### A/4/19/HH & A/5/19/L

The proposal is for an extension to an existing garage. The garage is located within the grounds of 'Weavers' which is a grade II Listed Building. Weavers is itself a two storey flint faced cottage with red brick dressings and quoins. The windows are timber casement.

PROPOSED PLAN OF GARAGE

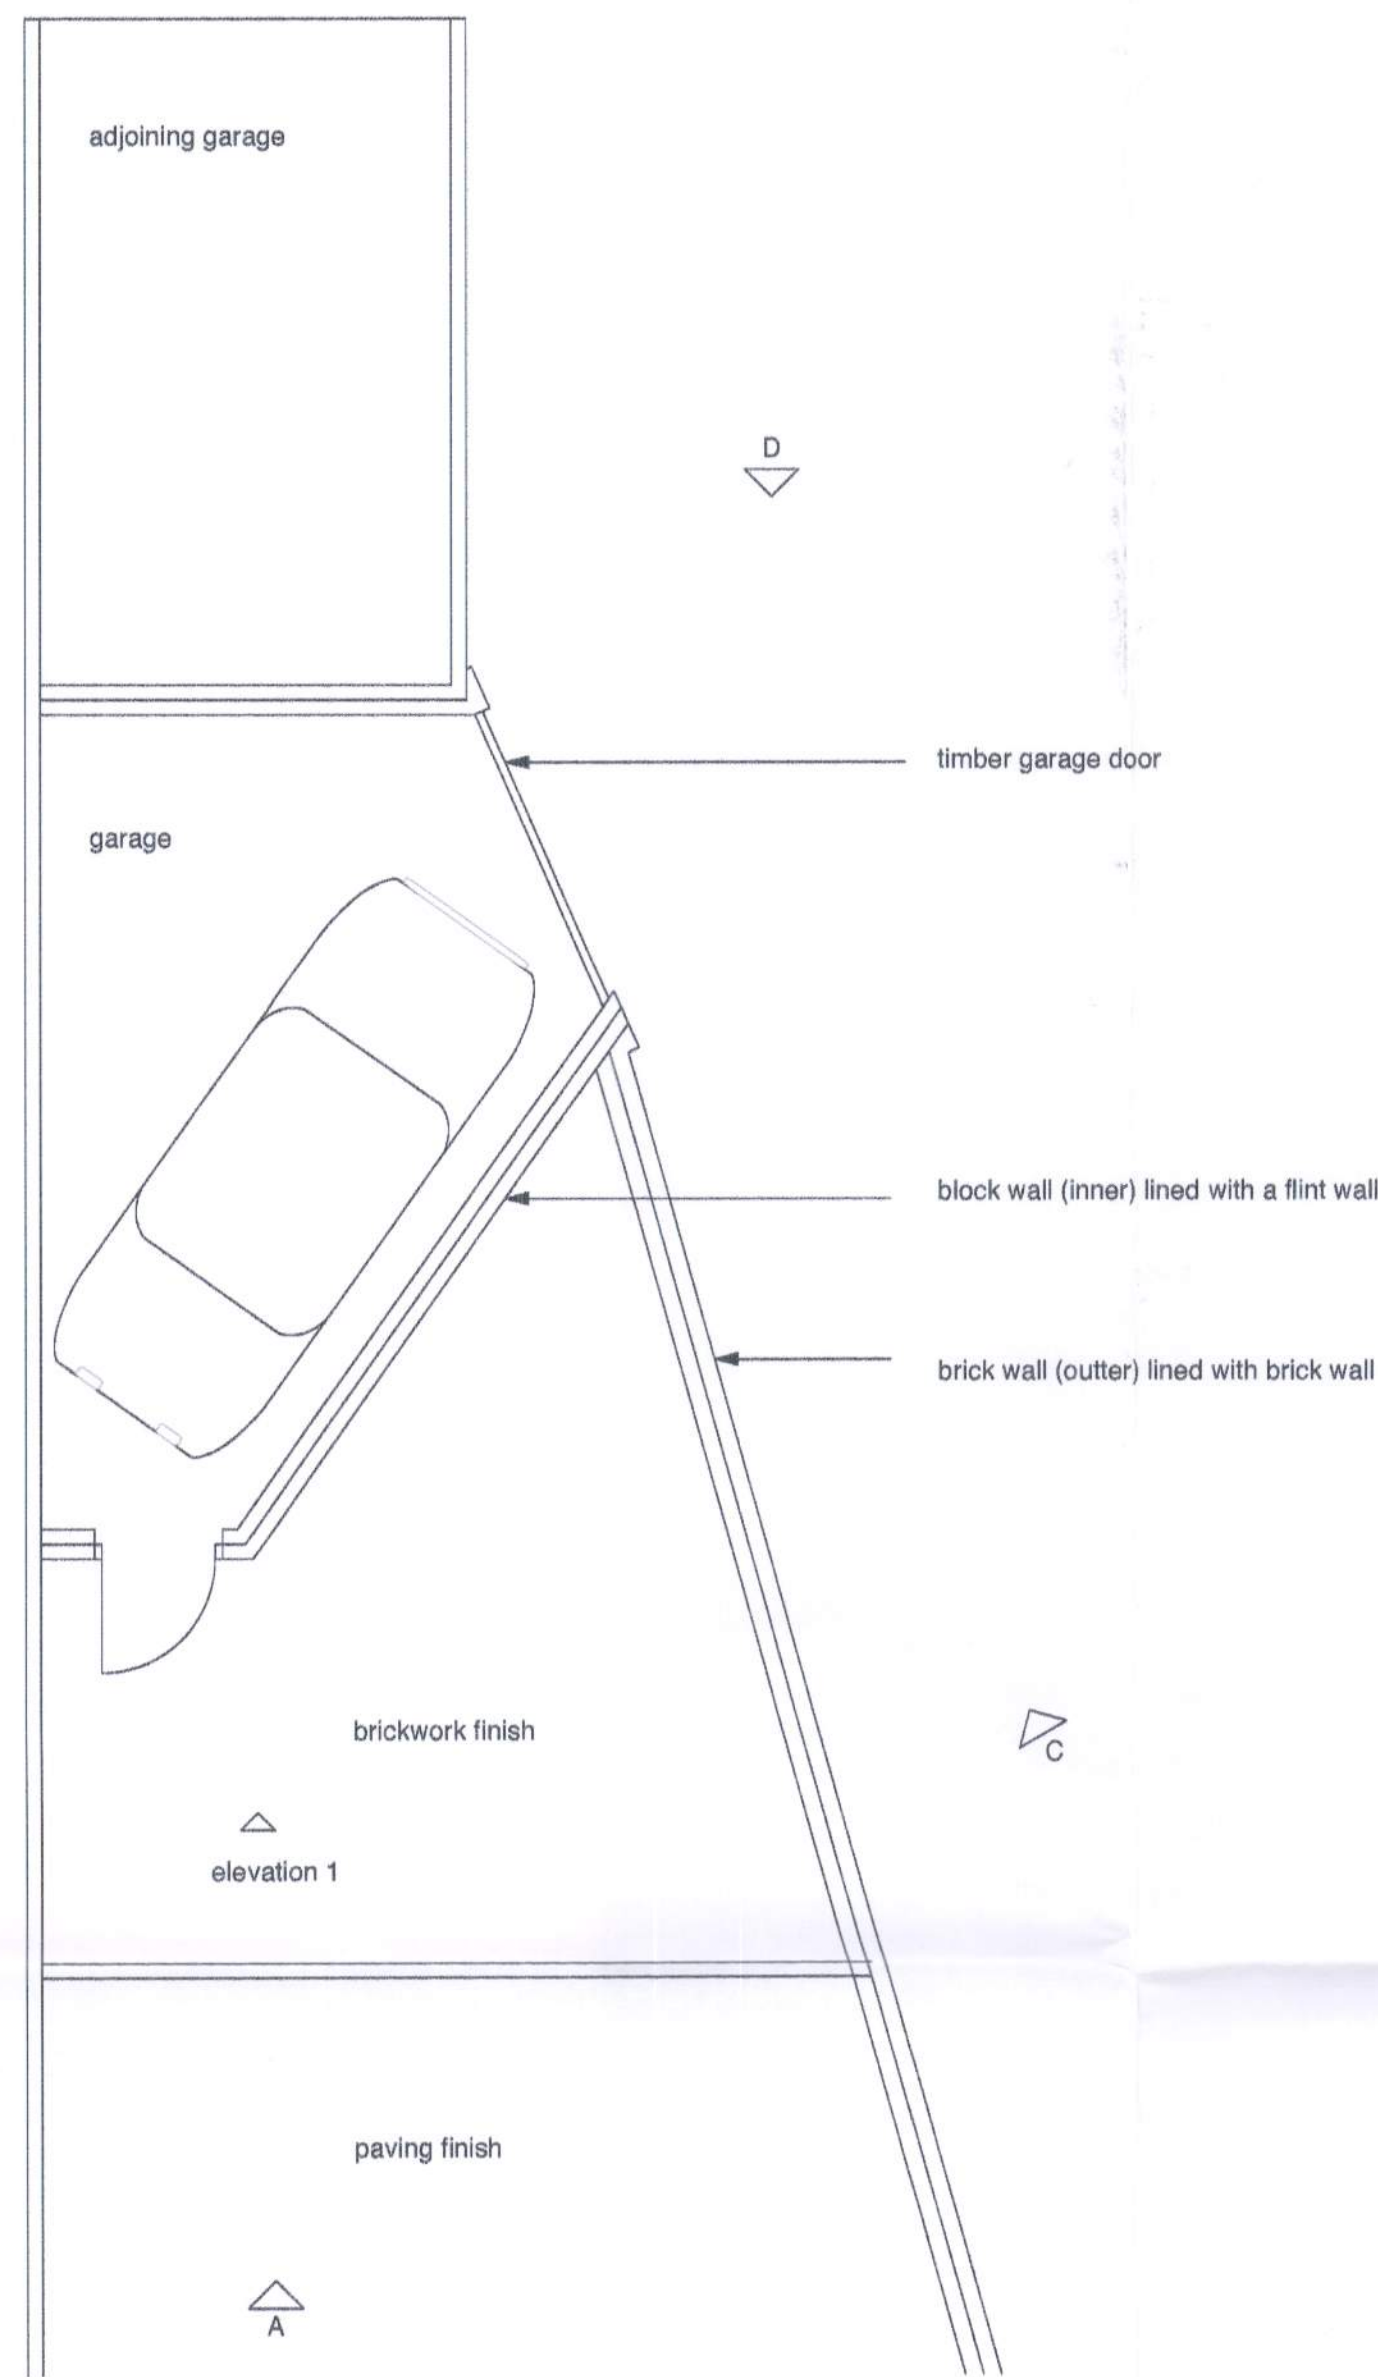
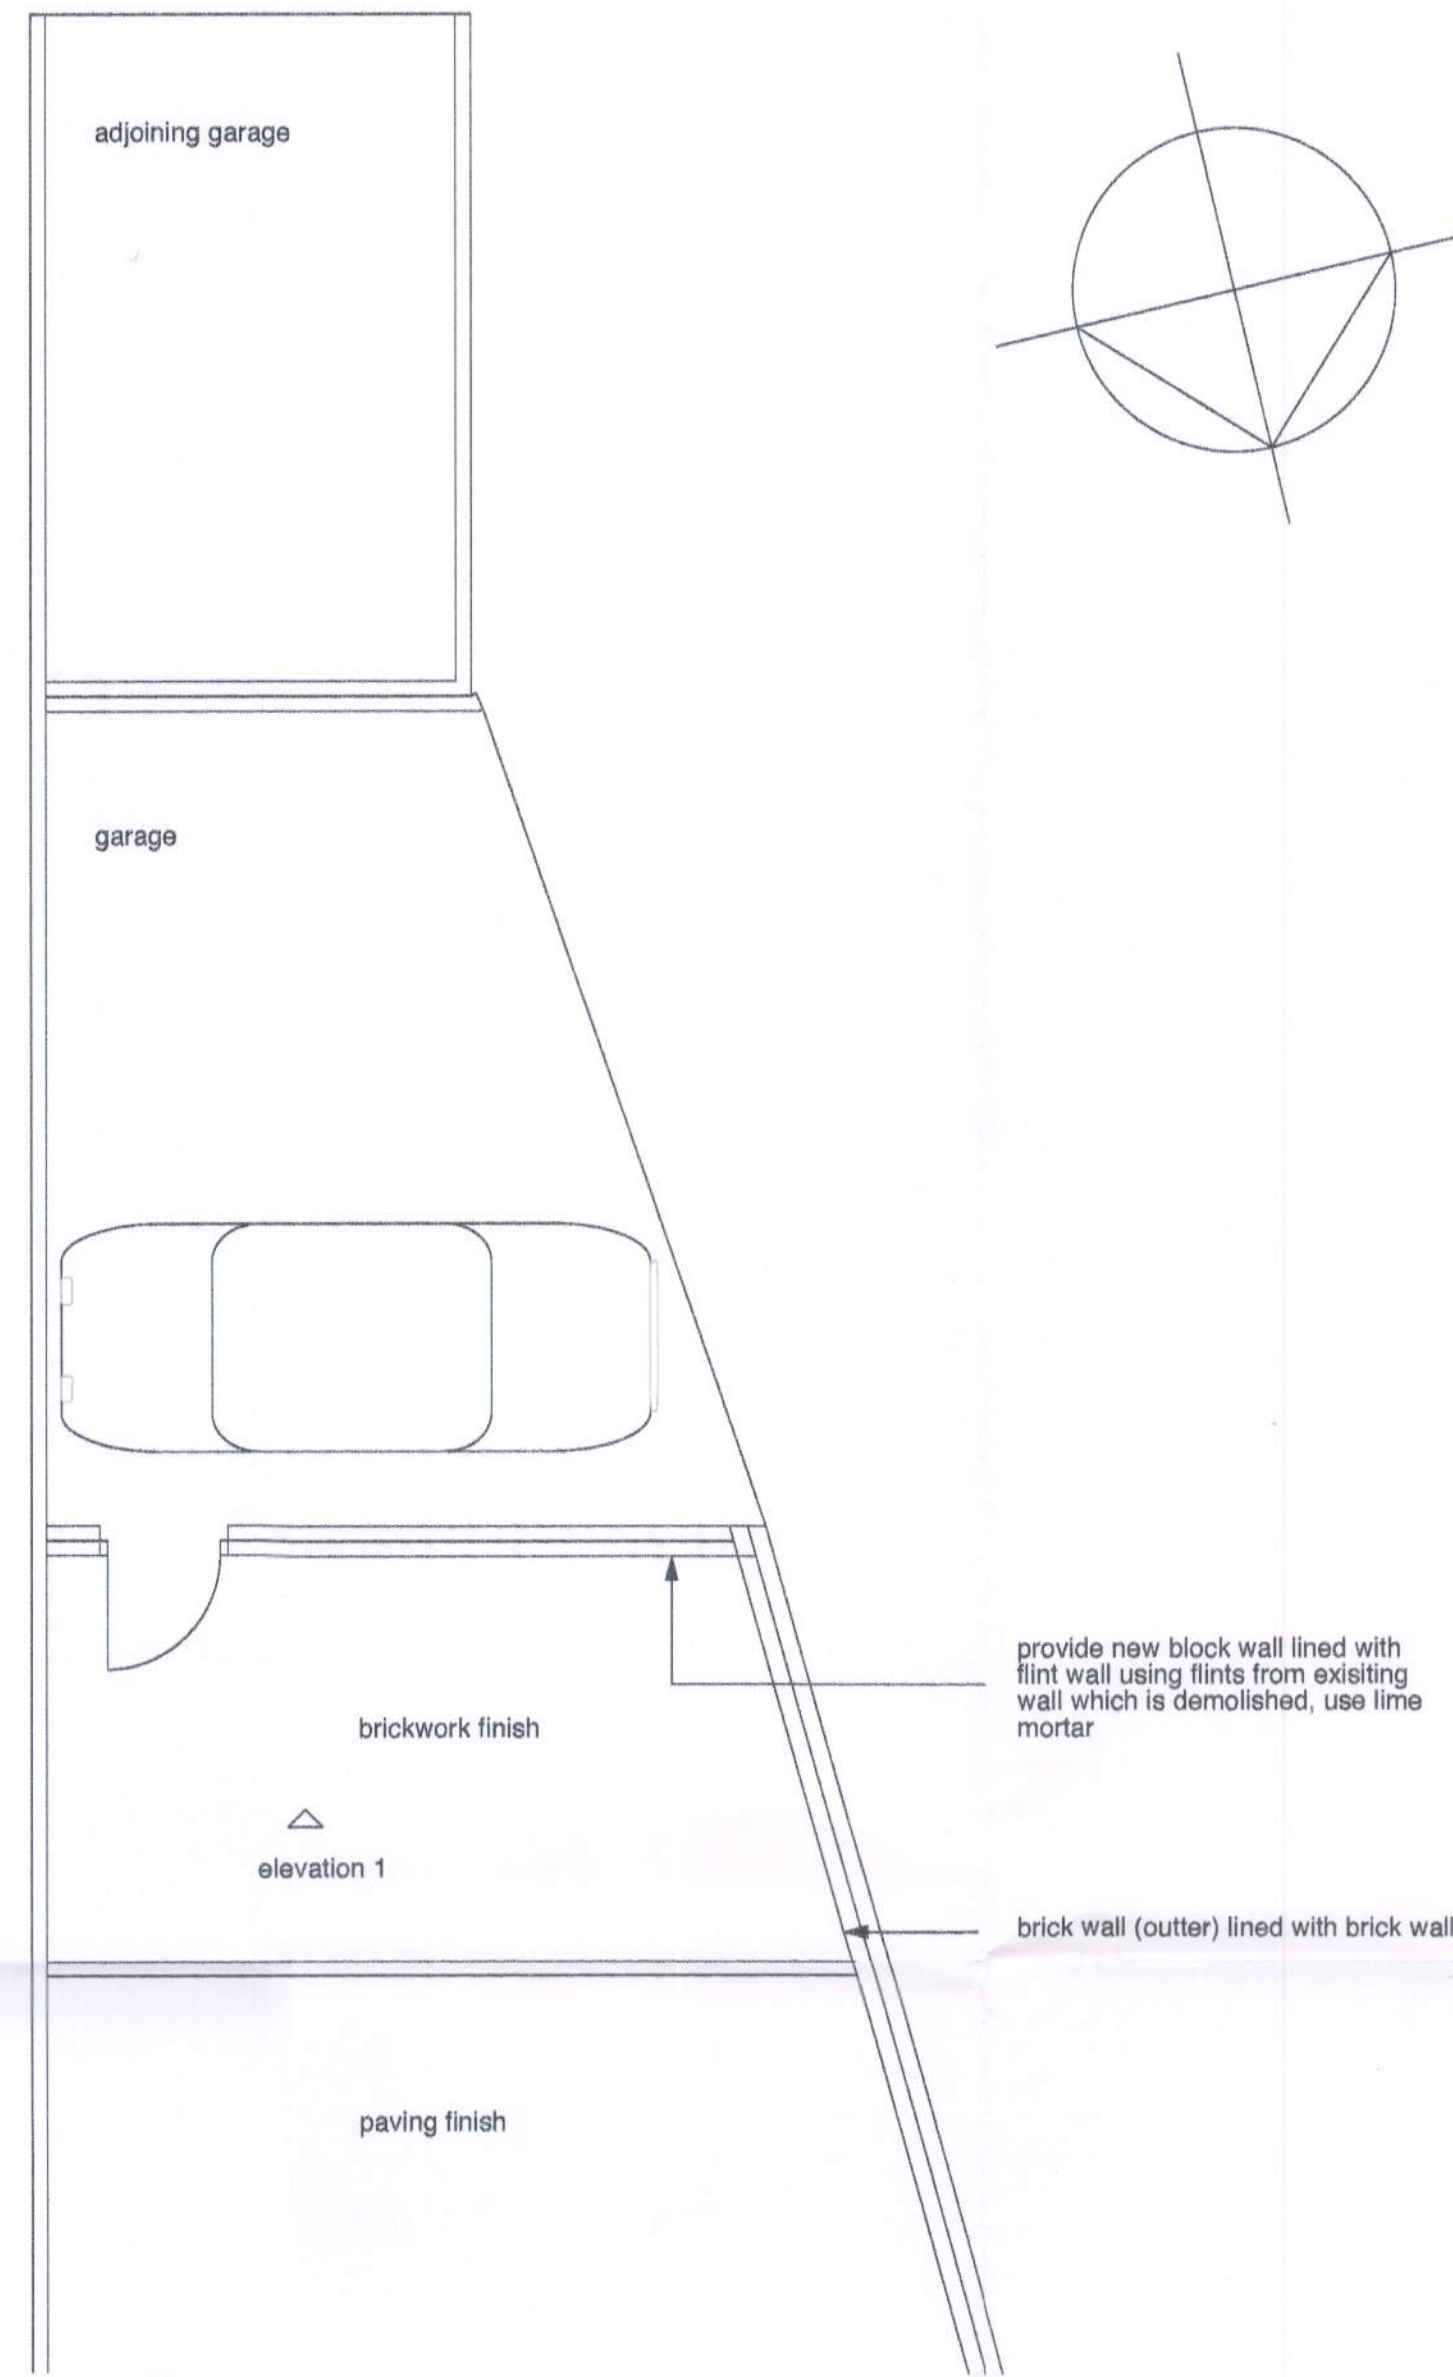
The proposal to extend the garage therefore appears to affect modern material which is of no significance. Further, the proposal removes an unusual shaped structure in the grounds of the listed building which can be supported. The use of the existing flint is positive and should be provided so that it reflects the quality of the existing walling.

Of some concern is the proposal to leave the larger garage open to the lane. Such a proposal will leave any contents exposed to the lane, which could potentially be unsightly. Is there a reason why replacement doors have not been proposed?

If minded to approve such a scheme, materials should match existing, and all existing flint should be retained and re-used.
